MORGAN AND MORECAMBE OFFSHORE WIND FARMS: TRANSMISSION ASSETS

Response to Section 51 advice

December 2024

Document reference: S_S51_1

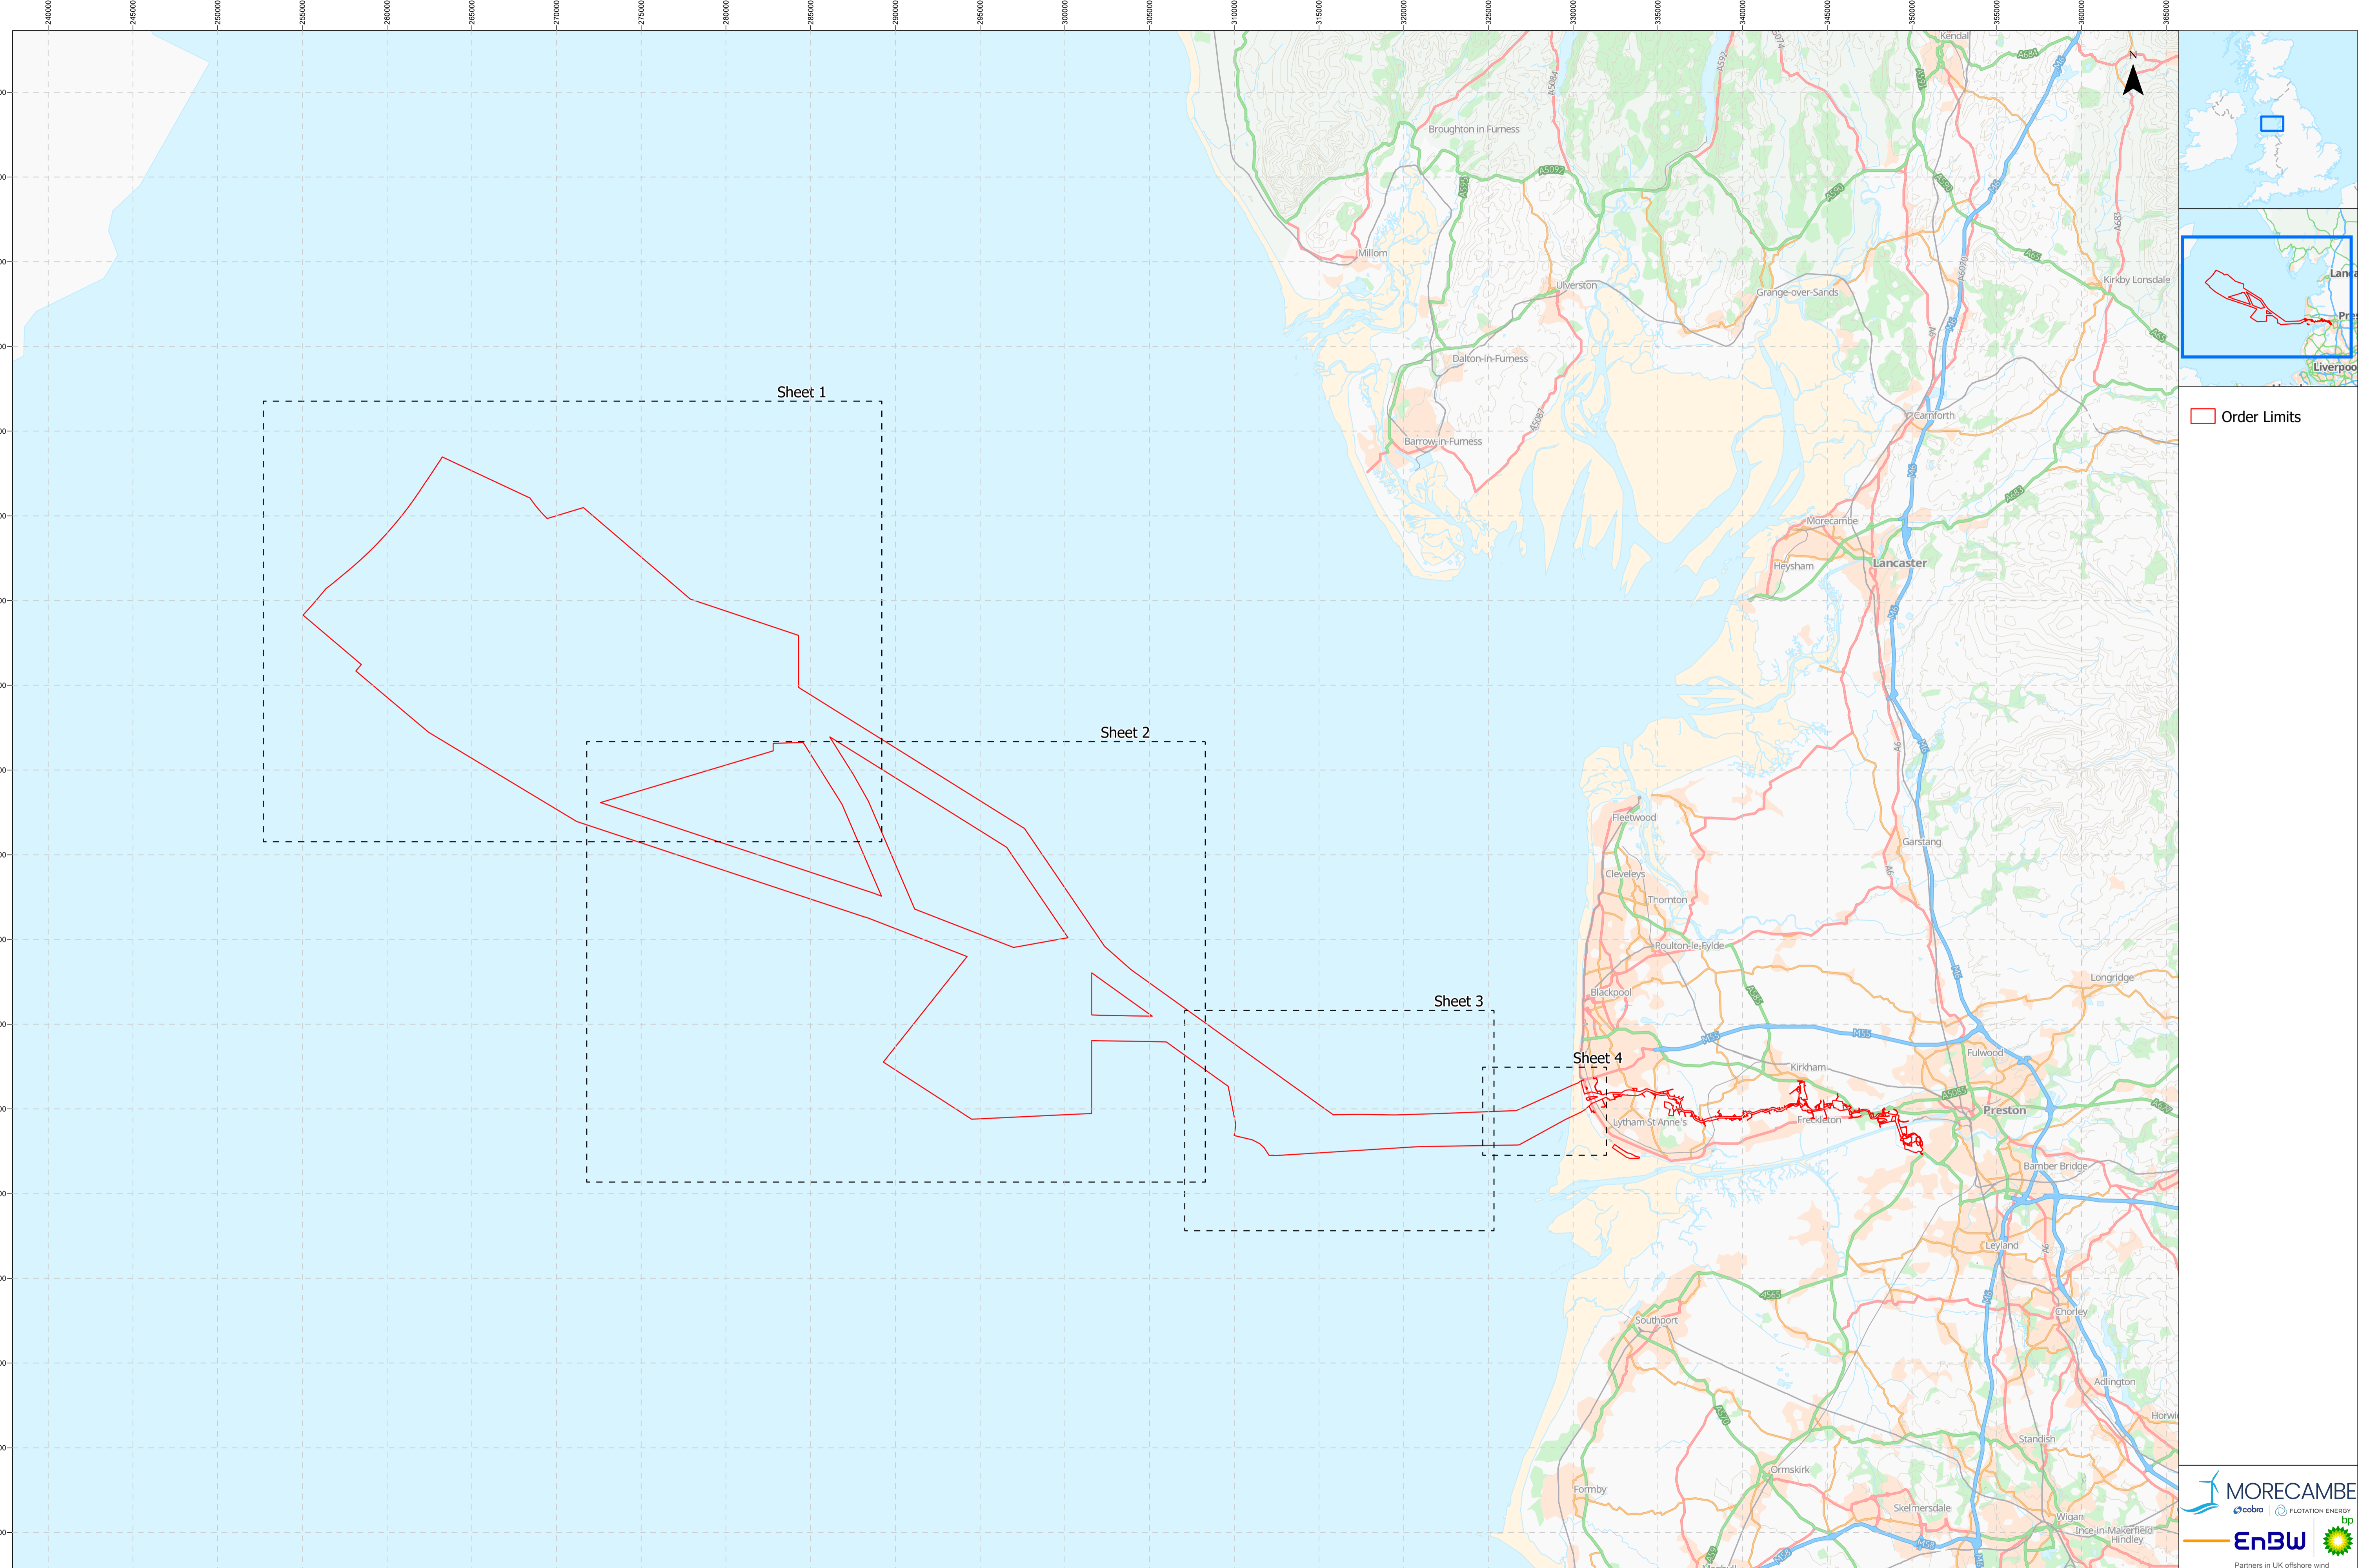
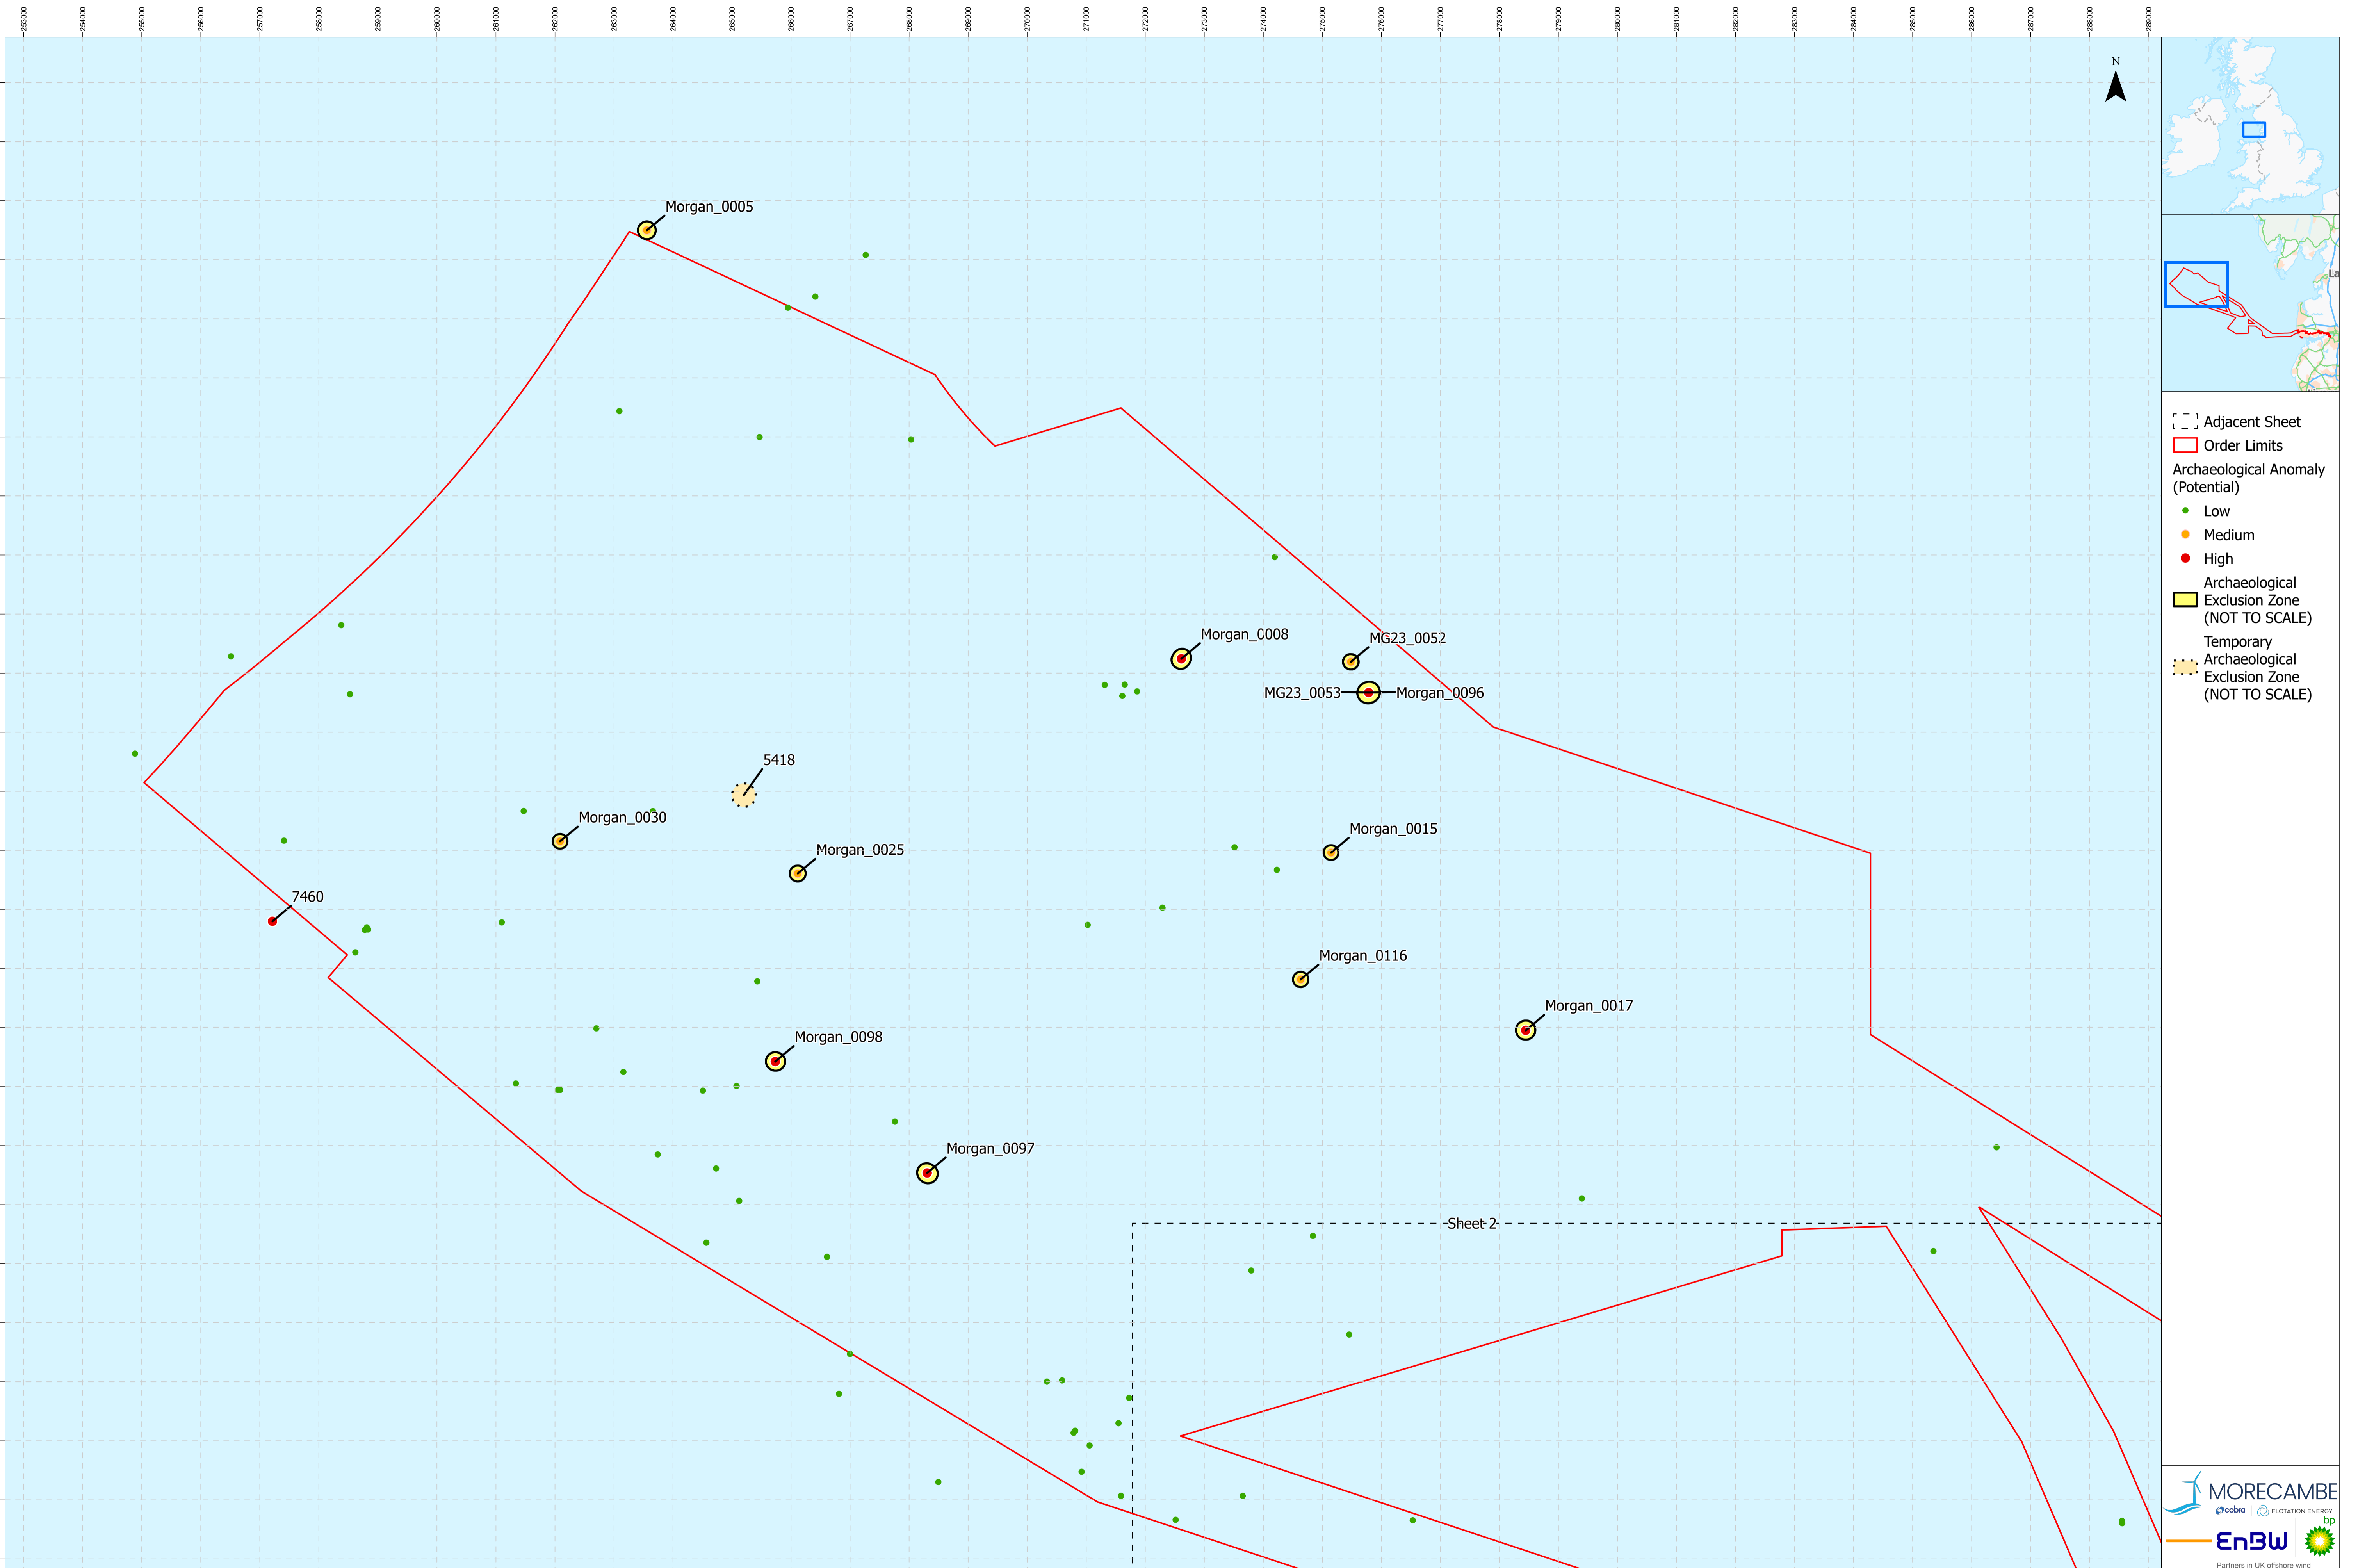
Topic	Section 51 advice	Applicants' response
		reference: B16/F02) to the Planning Inspectorate. The document also contains a Schedule of Changes.
Statutory and Non-Statutory Features of (The Offshore) Historic Environment Plan	<p>“Standalone figure B17 (Statutory and Non-Statutory Features of (The Offshore) Historic Environment Plan) only shows offshore exclusion areas rather than specific features, however the specific sites are shown on the ES figures. The Applicants are advised to provide an updated set of figures with appropriate labelling of the features being represented.”</p>	<p>The Applicants have reviewed the Offshore Historic Environment Plan alongside the ES Volume 2, Figure 8.5 and can confirm that the location of the geophysical anomalies shown as high medium and low are the same.</p> <p>The Applicants have reviewed the Offshore Historic Environment Plan alongside the ES Volume 2, Figure 8.6 and can confirm that Archaeology Exclusion Zone (AEZs) and Temporary Archaeology Exclusion Zones (TAEZs) are the same. To enable cross-referencing between the documents, named wrecks have been added to their corresponding ID reference. The Applicants have submitted the updated Offshore Historic Environment Plan (document reference: B17/F02) to the Planning Inspectorate. The document also contains a Schedule of Changes.</p>
